CITY OF ALBUQUERQUE

Re: MWS LLC Warehouse, 2501-B Karsten Court SE, Traffic Circulation Layout
Engineer's Stamp dated 11-16-04 (M14-D12H)

Re: MWS LLC Warehouse, 2501-B Karston Court SE, Grading and Drainage Plan

TRAFFIC CIRCULATION PLAN

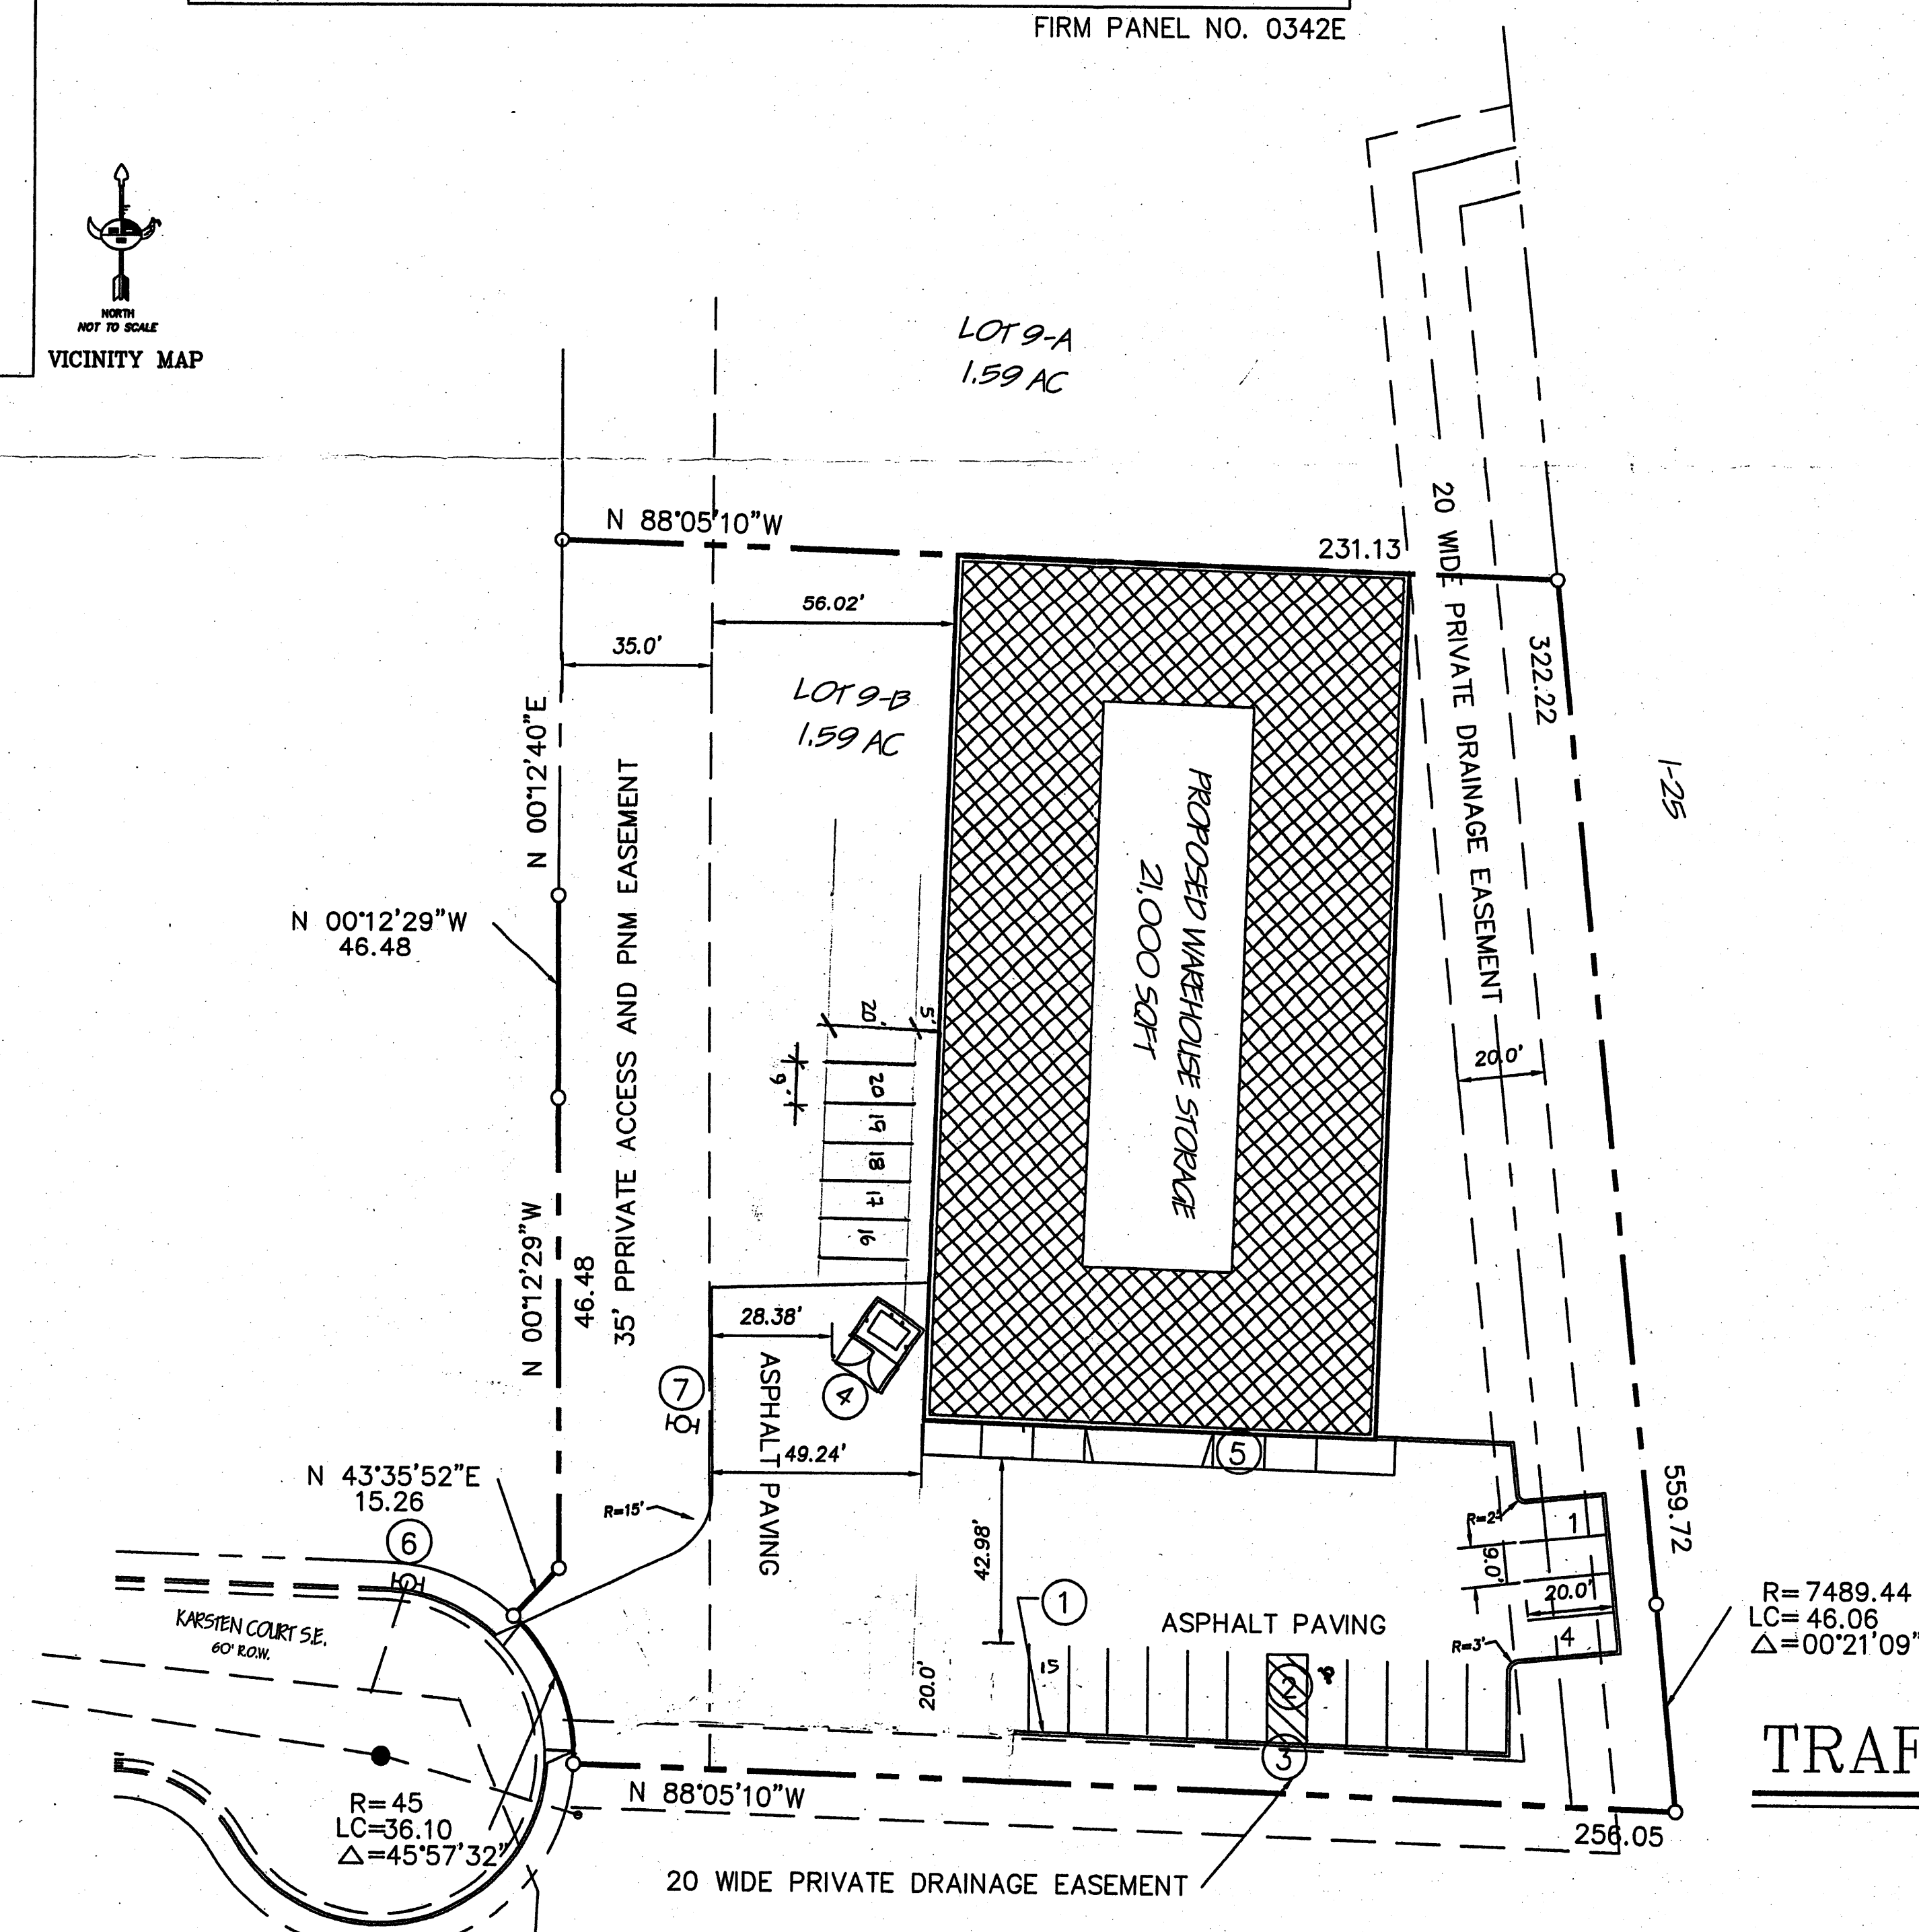
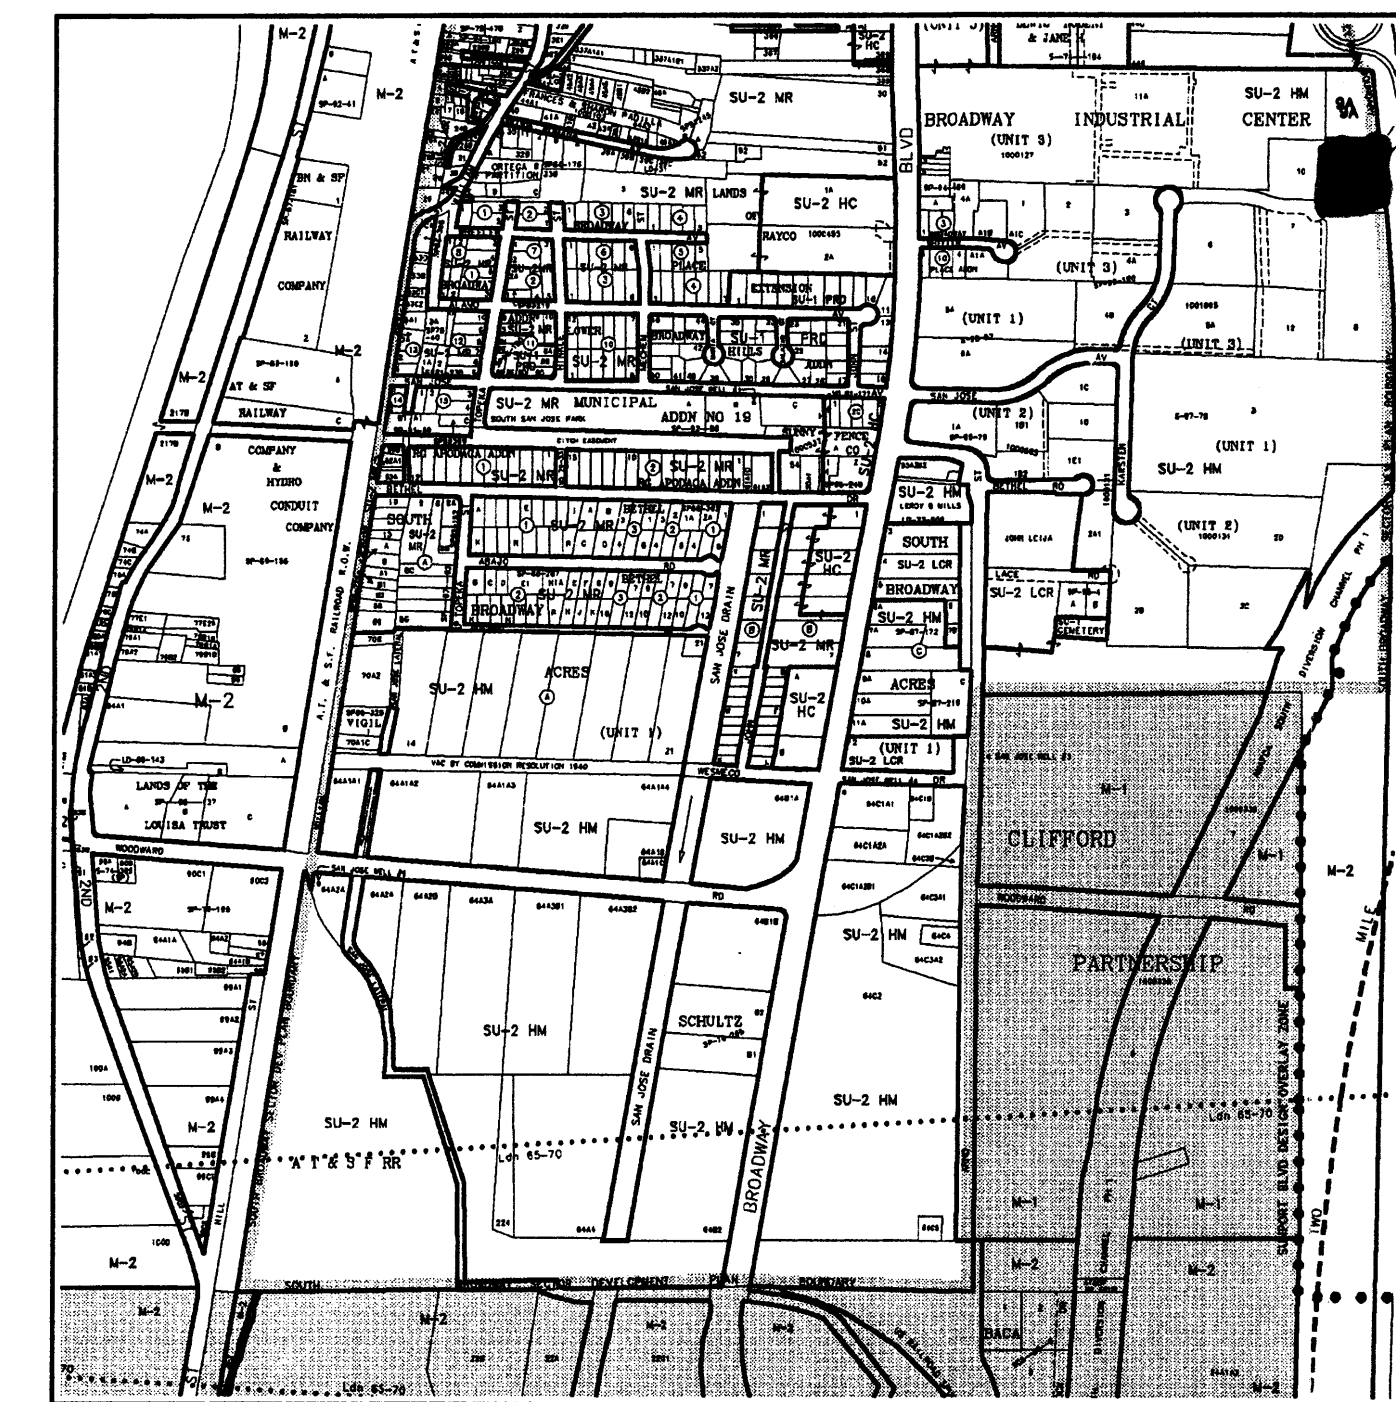
- I need you to certify on the site plan not with a pasted statement but with a statement on the plans or submit a letter of certification.
- You need to provide 8 feet of walkway (concrete) in front of existing building per David Kilpatrick discussion.
- Need a striped pathway from ADA parking stall to site entrance (in front of existing building entrance).
- Provide verification that parking stalls in front of existing building are in place (at present time pods are in place instead of parking stalls).
- You either need to provide an access easement or concrete curb to delineate between your property and the southern property adjoining your paved parking aisle.
